From: Simon Davis
Sent: 27 March 2018 10:04
To: Planning.Responses
Subject: FW: Aw/55/18/hh

From: Cllr. Phil Hitchins
Sent: 26 March 2018 17:30
To: Simon Davis
[REDACTED]
Subject: Aw/55/18/hh

PROPOSED ELEVATIONS

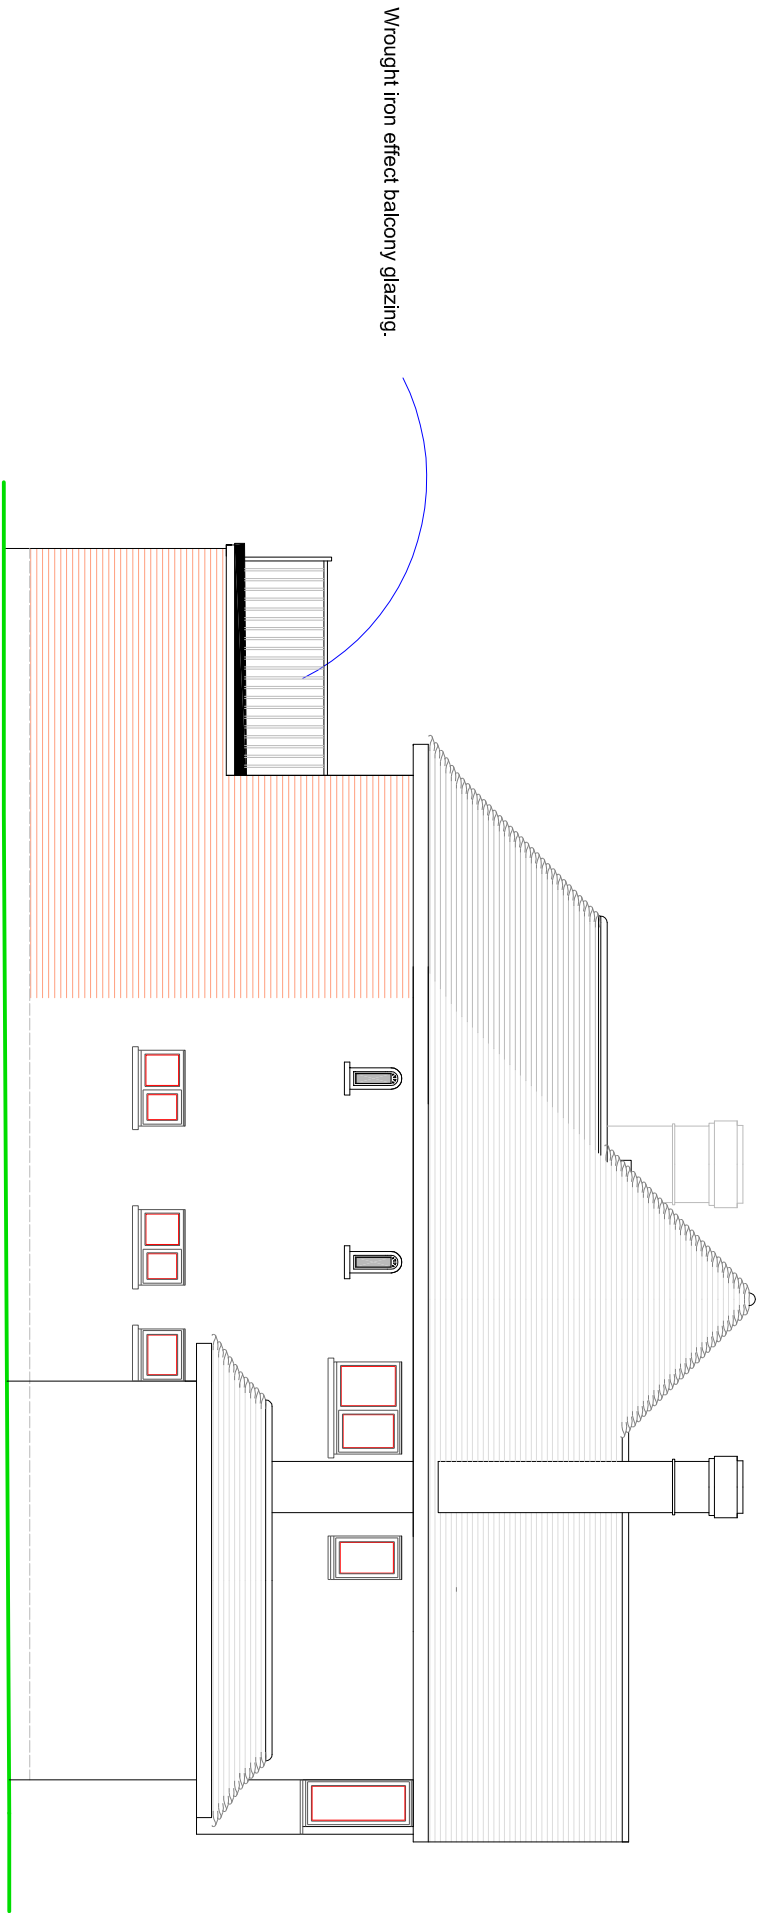
- 2) the proposed balcony would have a direct line of sight to the main bedroom of No2, as well as their Study and living room. It would also have direct sight over all of their rear garden. I have confirmed this this morning from all 3 rooms and from either end of the garden.

- 3) the east brick extension in view of its size would also have an adverse effect on their views and enjoyment when using the rooms I have mentioned as well as their entire garden. Such a large blank wall would, in my opinion, look like the side of a prison and not in keeping with neighbouring properties in this sensitive conservation area.
